ARACO Concrete  
Transportation Memorandum  
(LSC #194560)  
PCD File No.: PPR1950  
September 17, 2021

RE: ARACO Concrete  
El Paso County, CO  
Transportation Memorandum  
LSC # 194560  
PCD File No. PPR1950

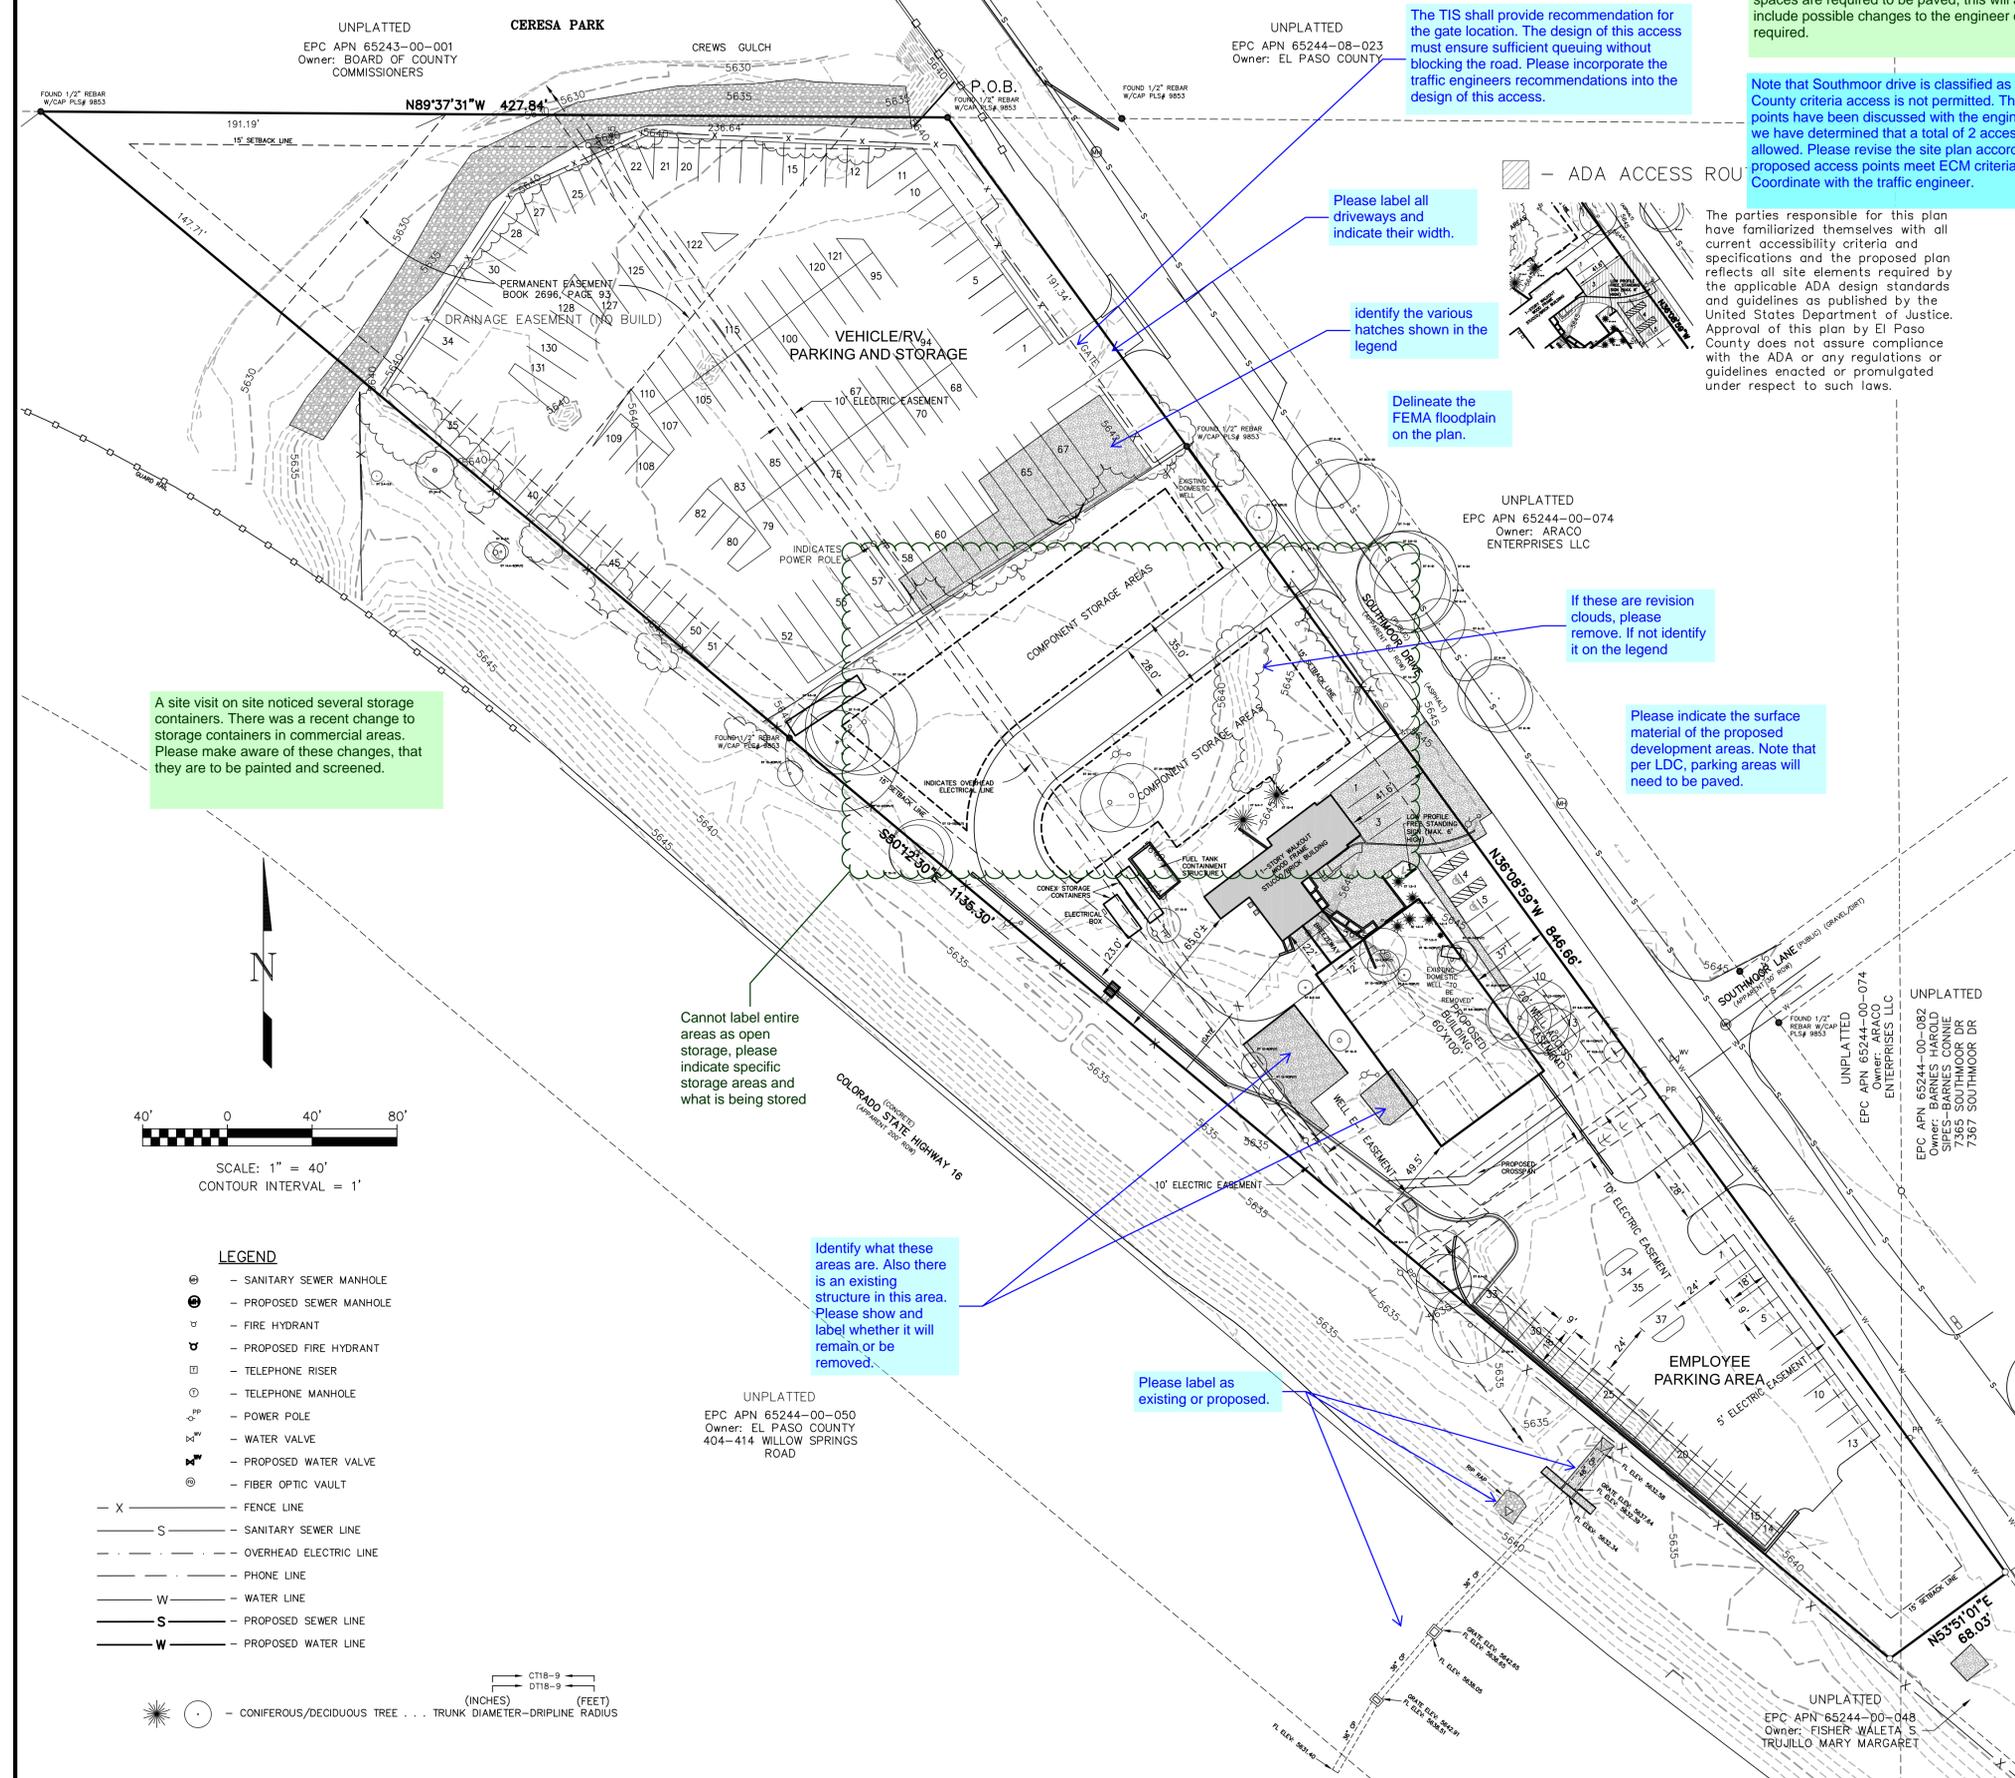
Please update the  
site plan on page 74  
of 76 to the latest  
site plan submitted.
